From: Mau, Russell E (DOH) <Russell.Mau@DOH.WA.GOV>
Sent: Thursday, October 9, 2025 9:16 AM
To: Melissa Schumaier; Ellie Myers
Cc: DOH EPH ODW Operations
Subject: RE: SD-25-00001 Easton Research and Rearing Facility Outfall - Notice of Application, SP3801 and SP013C

The Department of Health (DOH) Office of Drinking Water (ODW) has reviewed the application and has the following official comments:

Subject: SD-25-00001 Easton Research and Rearing Facility Outfall - Notice of Application

SITE PLAN - NORTH

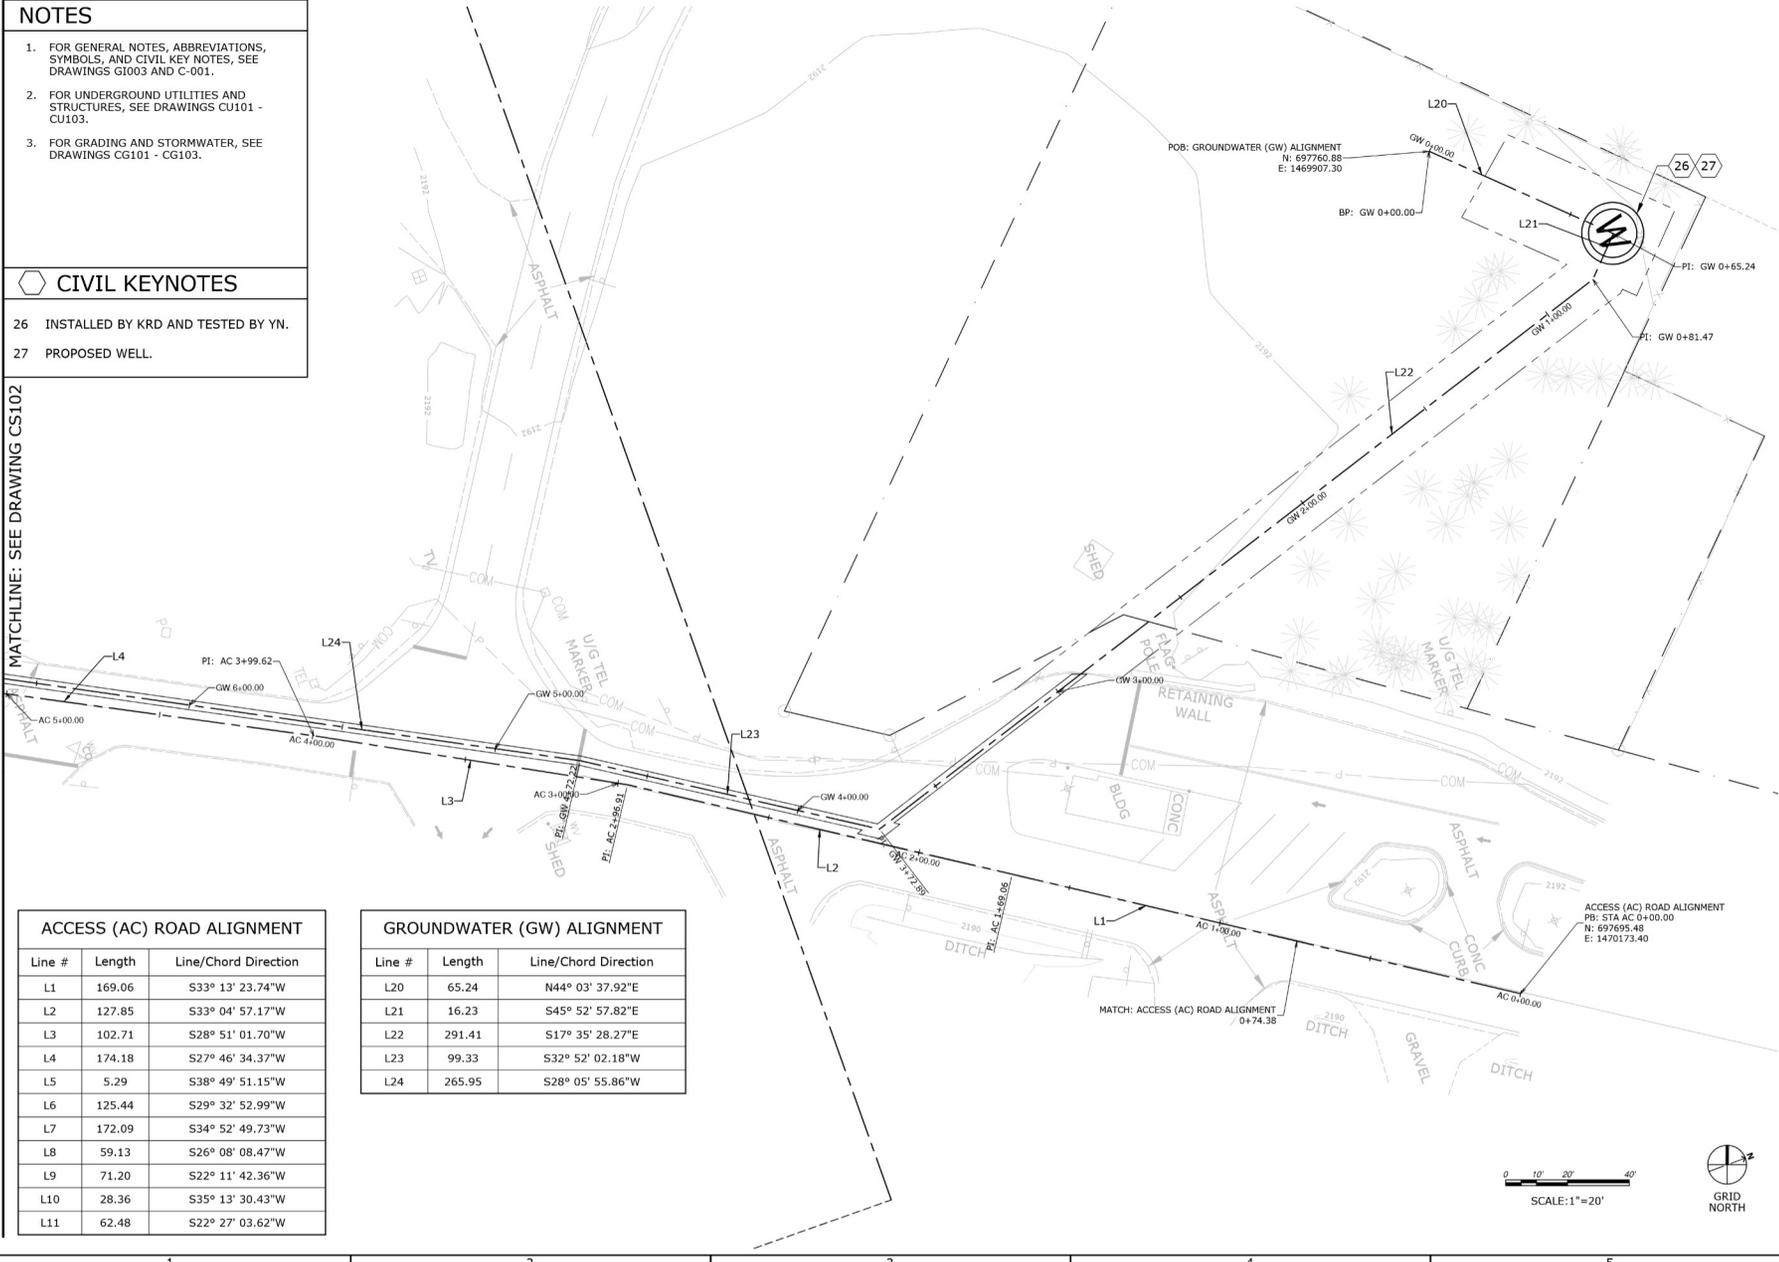
1. The applicant proposes a new groundwater well to provide water, for “drinking” water uses, within the proposed building – DOH ODW seeks the following information:
 - Is the proposed property within the service area of the “Easton Water District” (ID #42700)?
 - What is the number of persons who will be on-site per day and per month?

- To connect to the “East” park, this system has connection availability. For the “connection”, DOH requires submittal of the design of the interconnecting piping and an estimate of the water use by the applicant's facility.
- To connect to the “West” park, this system currently has no available connections, but that is because its “capacity” was never evaluated. To connect, DOH requires completion of a capacity analysis of the “West” park system, including estimated water usage by the applicant's facility, and if this capacity analysis shows sufficient capacity, then submit of the design of the interconnecting piping.

For any design submittals and for any capacity analysis calculations, DOH requires these to be prepared by a Professional Engineer licensed in the State of Washington.

Additionally, the applicant had considered another well with a well tag “AFT387” – this well is not an approved well, so the applicant would need to complete source approval and complete a new water system application (both required to be completed by a Professional Engineer licensed in the State of Washington); however, as noted in my original email below, the applicant needs to answer that set of questions so that we can determine if, as a standalone entity, it meets the definition of either a Group A or Group B water system.
